8 Bushby Ave

SUBMISSION OF PLT PLAN R/49/09.

MINOR BUILD MODIFICATION OR
AMENDMENTS

SIDE ELEVATION (W)

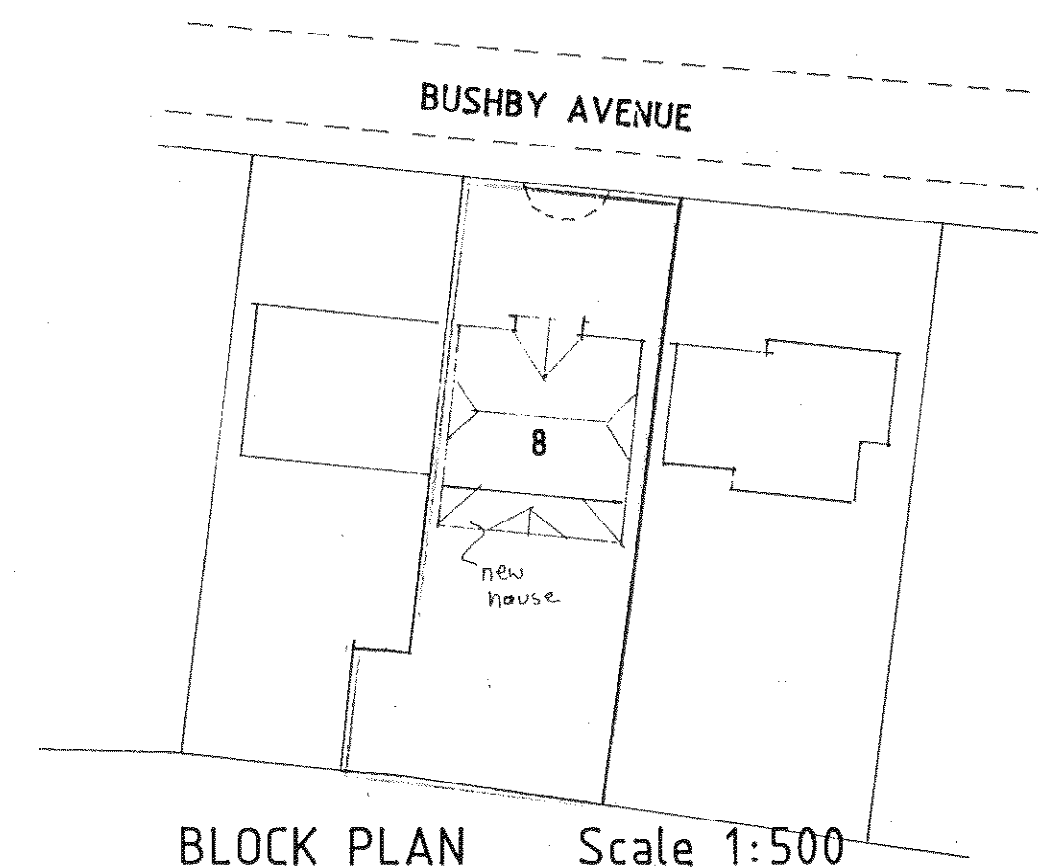
EXPANSION JOINT AGREED WITH BCC

DELETION OF 1NO WINDOW H/L W/ SIDE

ADDITION OF SIDE KITCHEN WINDOW

DELETION OF CLASS SIDE DOOR
